H2Teesside Project

Document Reference: 9.7: Statement of Common Ground between H2 Teesside Limited and Natural England

Date: November 2024

**Statement of Common Ground between the H2 Teesside Limited and
Natural England**

AECOM

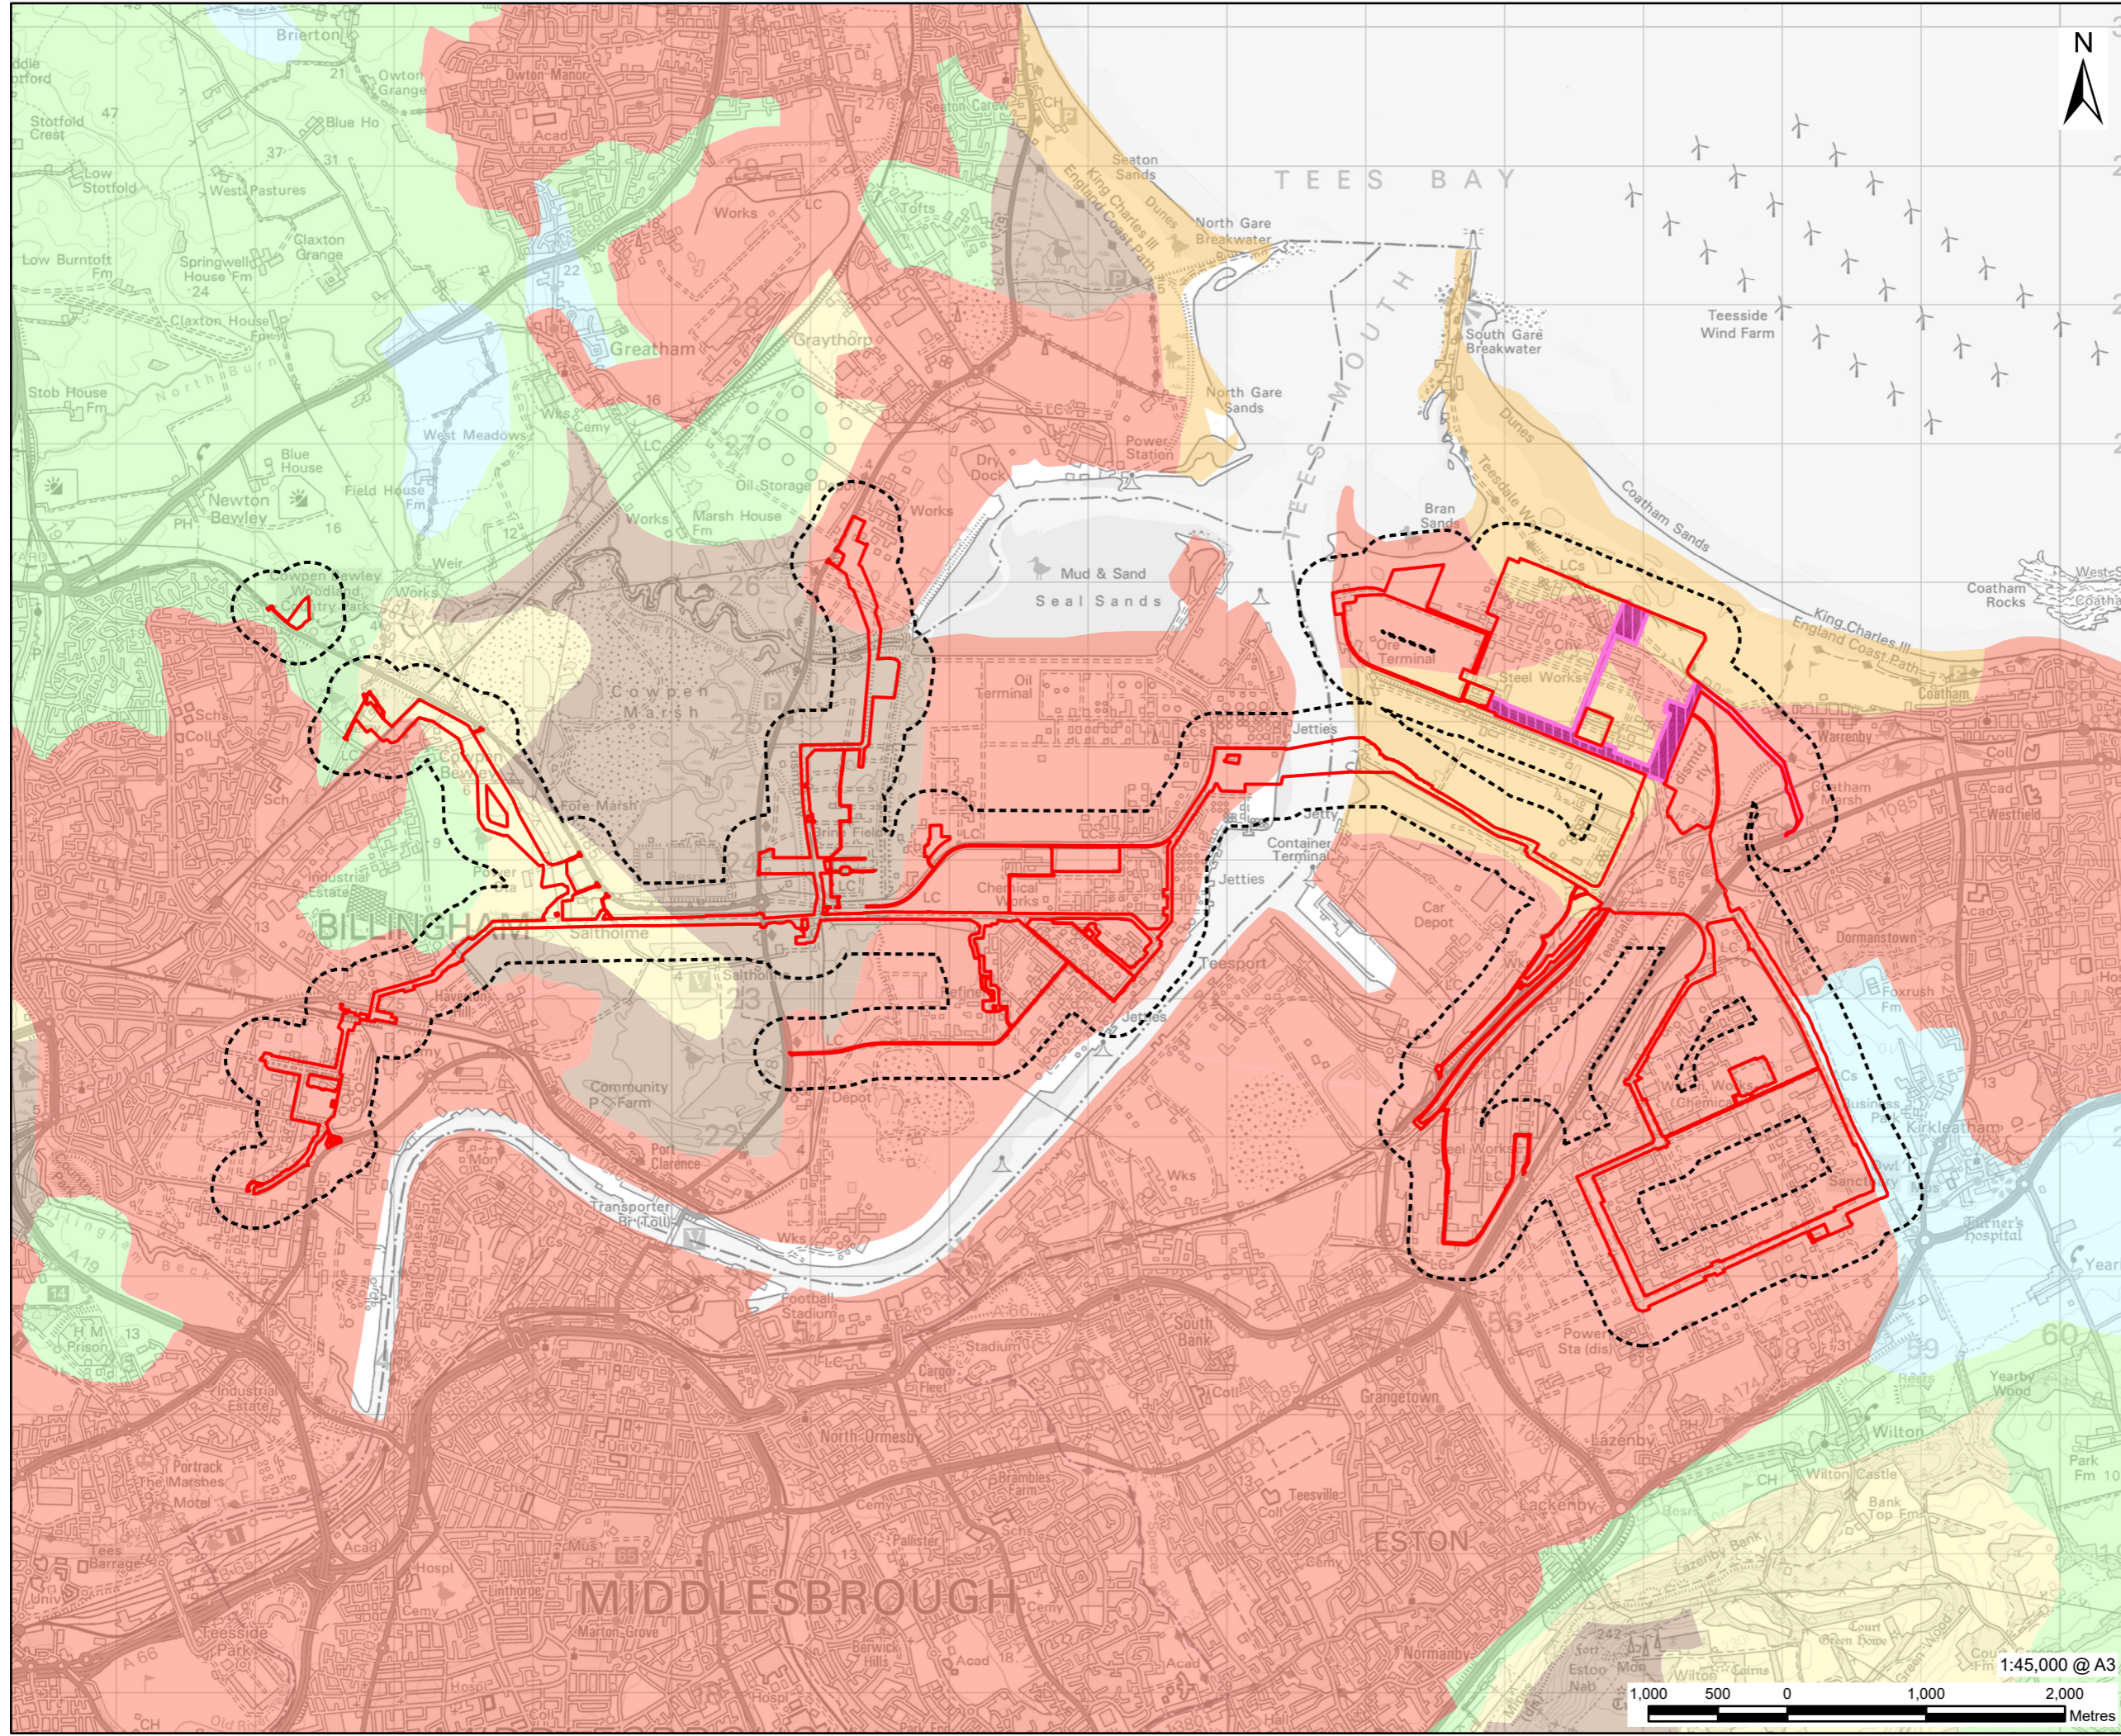
11.	Best and Most Versatile Land	NE35	<p>BMV land across the Proposed Development Site is limited, with the majority of the Main Site and Connection Corridors classified as Urban and Non-</p>	<p>NE considers appropriate mitigation to prevent the loss of BMV land, should be set out within the assessment. This would require a detailed</p>

SOCG ID	MATTER	REPRESENTATION REFERENCES	APPLICANT POSITION	NATURAL ENGLAND POSITION
			<p>Agricultural. A small portion of the Hydrogen Pipeline Corridor north of the River Tees has land classified as Grade 3, 4 and 5. As a worst case scenario Grade 3 land, at the Cowpen Bewley Replacement Land, is assumed to be Grade 3a, making it BMV land for the purposes of the assessment presented in ES Chapter 10 ‘Geology, Hydrogeology and Contaminated Land’ [APP-062].</p> <p>Taking into account the above, the Applicant does not propose to undertake supplementary ALC surveys of the Proposed Development Site at this time. However, the Applicant recognises the need for careful soil management and handling. The Framework CEMP [APP-043] will be amended to include the production of a Soils Management Plan (‘SMP’), included as part of the Final CEMP, produced prior to construction.</p> <p>ES Figure 10-1 [APP-110] is for artificial geology/made ground only. ES Figure 10-19 [APP-137] will be updated to include the correct colours for each ALC grade at Deadline 2.</p>	<p>ALC survey of the pipeline routes to inform restoration. The following actions should be undertaken:</p> <ul style="list-style-type: none"> • For all areas in which POST-1988 ALC Survey information is not available, an ALC survey should be undertaken. • The colours used for mapping should be updated to match standard ALC colours. • The soil information presented (Figure 10-1 [APP-110]), should include the mapped soil associations. • The consideration of soil handling should be expanded in a Soils Management Plan (SMP). <p>D4 update: Natural England welcomes the updated Figure 10-19, submitted into the Examination at Deadline 2 and the commitment to preparing a Soil Management Plan in the Framework CEMP, submitted into the Examination at Deadline 2.</p> <p>Natural England advises a detailed ALC survey for the full Study Area should be conducted by</p>

SOCG ID	MATTER	REPRESENTATION REFERENCES	APPLICANT POSITION	NATURAL ENGLAND POSITION
			<p>No further updates are anticipated to be submitted.</p> <p>D4 update: The Applicant will continue to discuss this matter with Natural England through the SoCG between the two parties.</p>	<p>the Applicant, in which post-1988 ALC survey information is not available.</p>
12	DCO Requirements	n/a	<p>The Applicant is continuing discussions with Natural England regarding matters raised in their Relevant Representation and by extension the specific wording of Requirements in the draft DCO.</p>	<p>The drafting of DCO Requirements 4, 14, 15 and 20 remain under discussion as discussion continues around Natural England’s Relevant Representation.</p> <p>Natural England is continuing discussions with the Applicant on matters pertaining to the draft DCO.</p>
